Rezoning Transportation Analysis

Petition Number: 2020-125

General Location Identifier: Tax ID 05112203

Date	Description
10-26-20	First Review
11-30-20	Second Review
12-28-20	Third Review

**RZ-1.0**

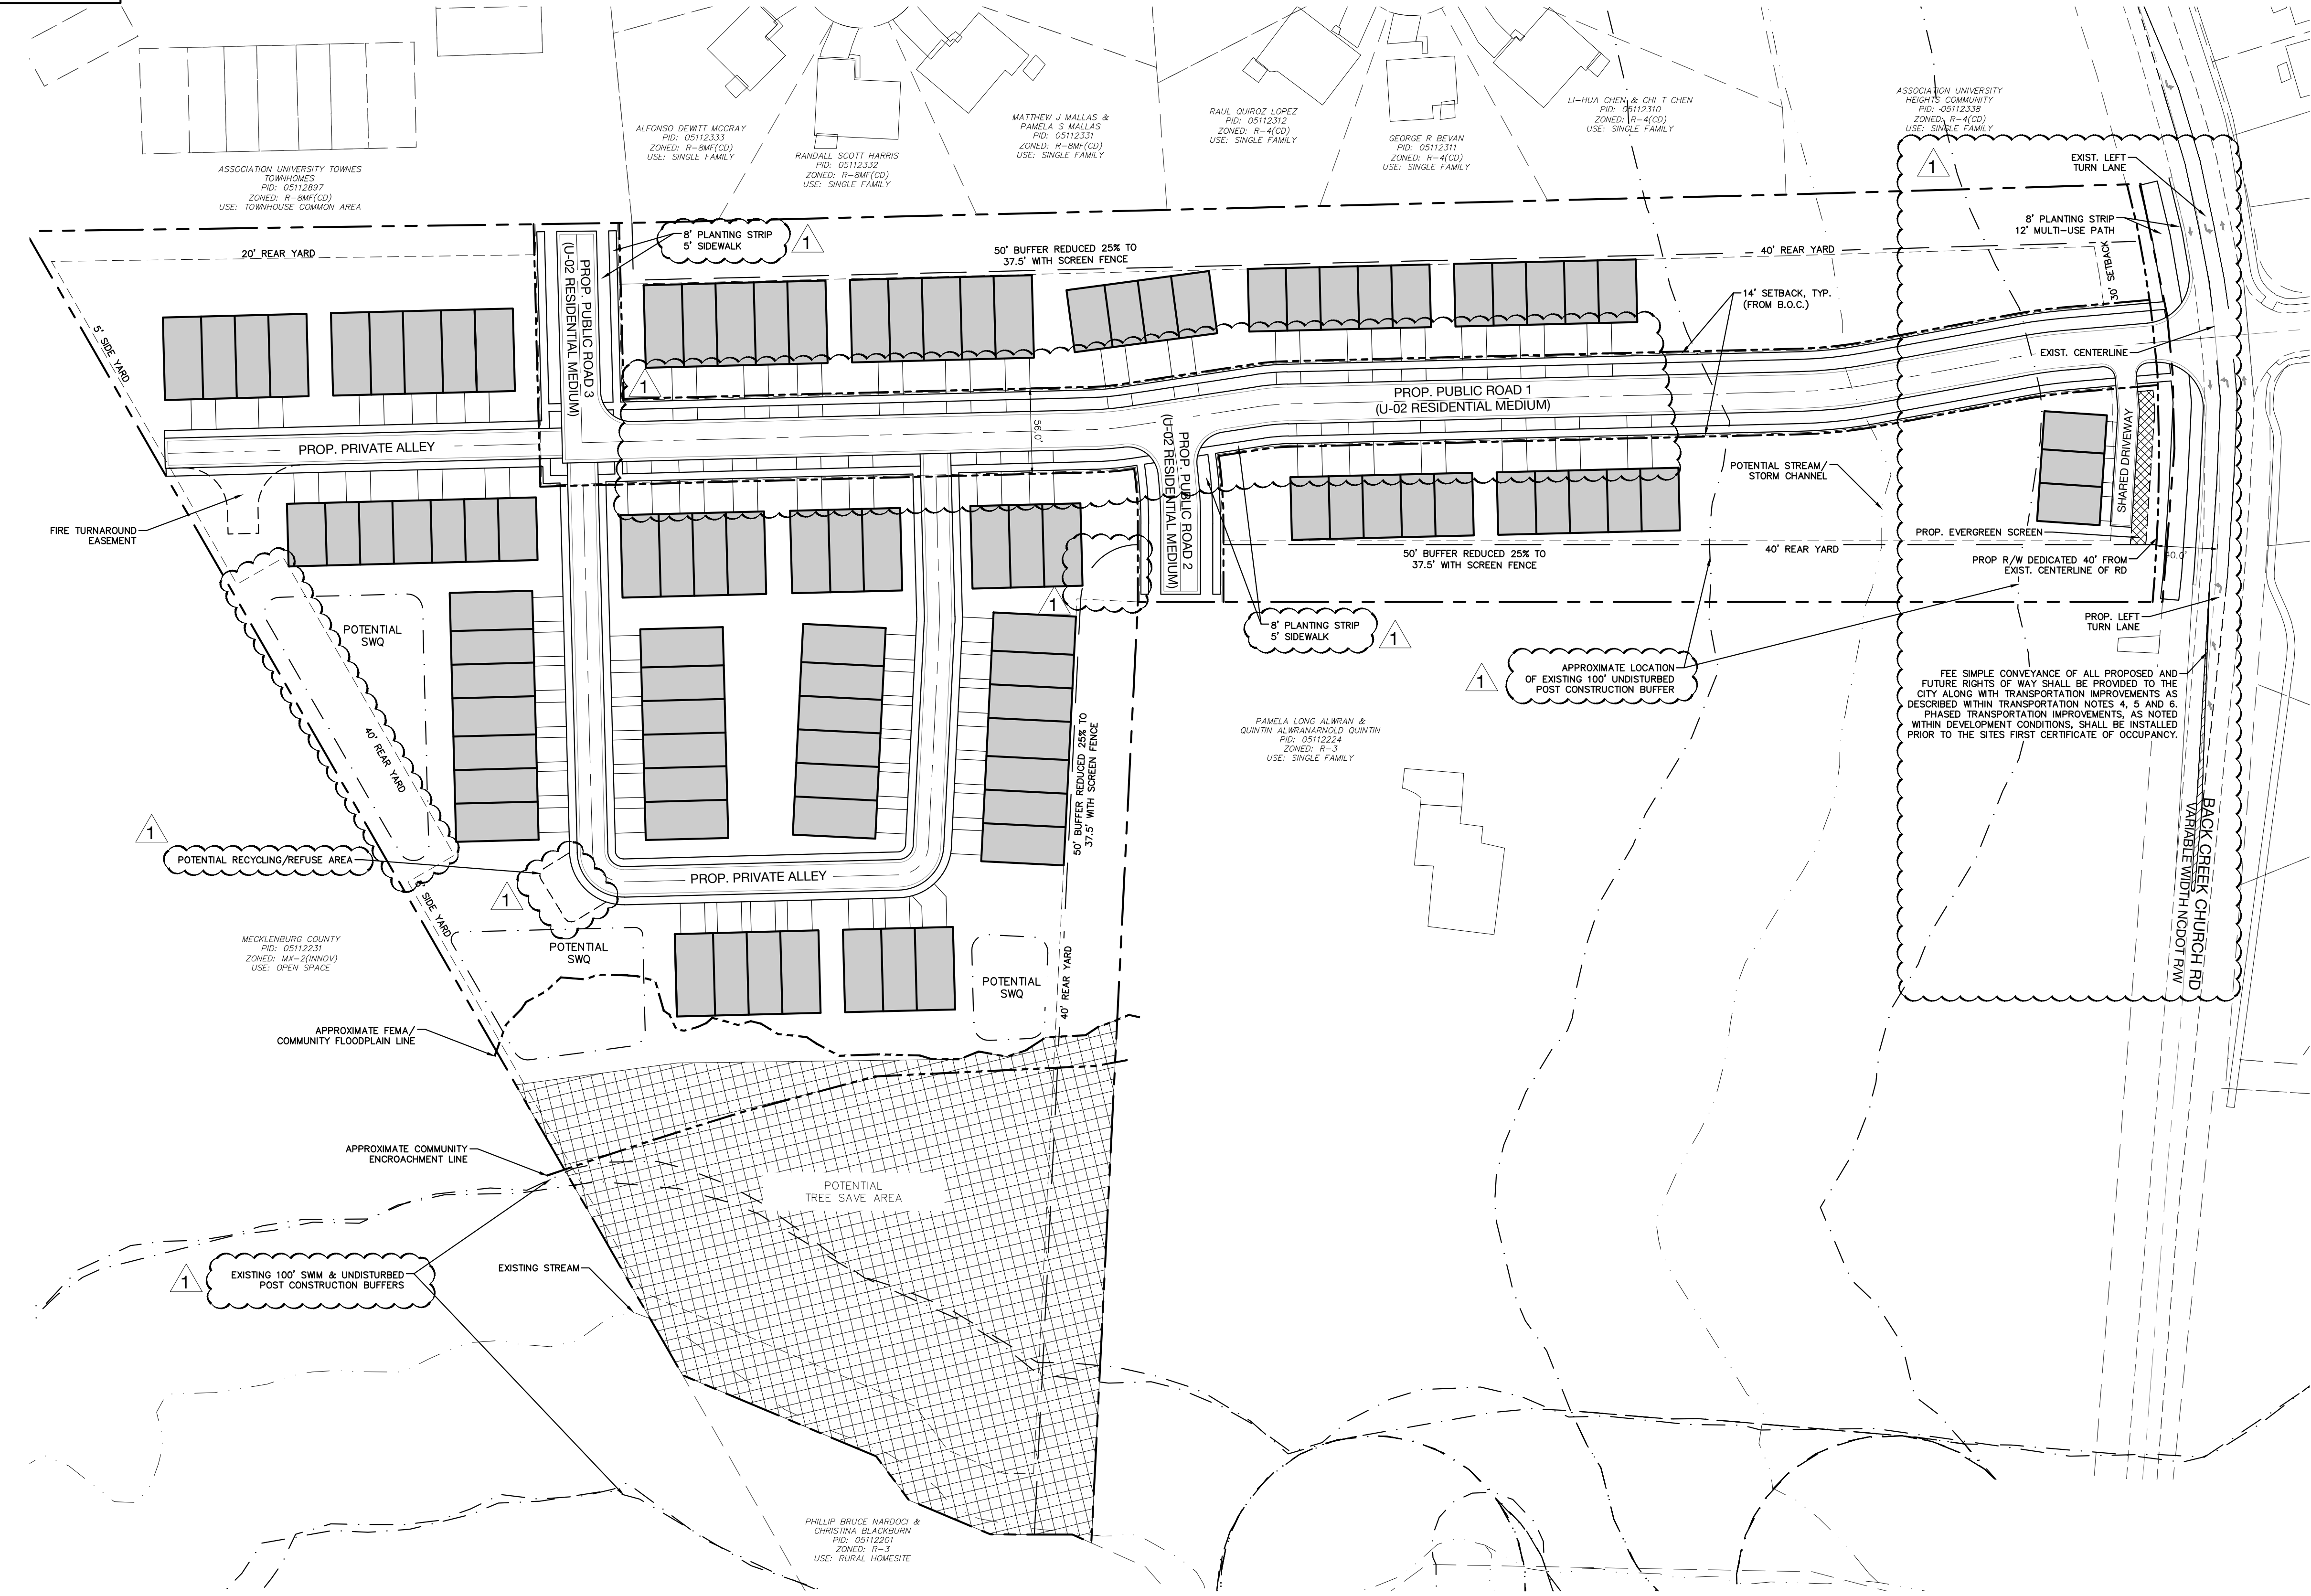
1. **Curbline:** The proposed zoning district has a setback measured from back of the existing or proposed future curbline.
 - a. ~~**Back Creek Church Road:** The back of curb and gutter shall be located at 19' from the roadway centerline. This accounts for two 11' through lanes, 2.5' curb and gutter, and an 11' left turn lane at the site's entrance.~~

The site plan should show the curb and gutter labeled and dimensioned from the centerline for each road.
2. **Traffic Study:**

3. ~~Revise the site plan and conditional note(s) to commit to dedicating 40' minimum right of way from the Back Creek Church Road centerline. The site plan shall label and dimension the right-of-way from the road centerline.~~

4. ~~Revise the site plan and conditional note(s) to commit to constructing an 8-foot planting strip, and 6-foot sidewalk on all Local roads per Chapter 20 and CLDSM Standard U-03. While the site plan shows both, they need to be labeled and dimensioned accurately from the back of curb and gutter.~~

5. ~~The site plan and conditional note(s) revisions are needed to commit to installing a 12' multi-use path along Back Creek Church Road to meet the City Charlotte BIKE Policy.~~

6. ~~Revise the site plan and conditional note(s) to commit to providing a left turn lane into the development as required for developments that generate over 500 trips per day, as per NCDOT's policy on street and driveway access.~~

7. ~~The proposed driveways do not meet the minimum spacing requirement of 20' per the City of Charlotte Driveway regulation. Revise site plan and conditional note(s) to commit to constructing alley loaded~~

~~homes along public roads **OR** provide shared access driveways to help produce a more organized and pedestrian-oriented form of access management per the City of Charlotte Driveway Regulation.~~
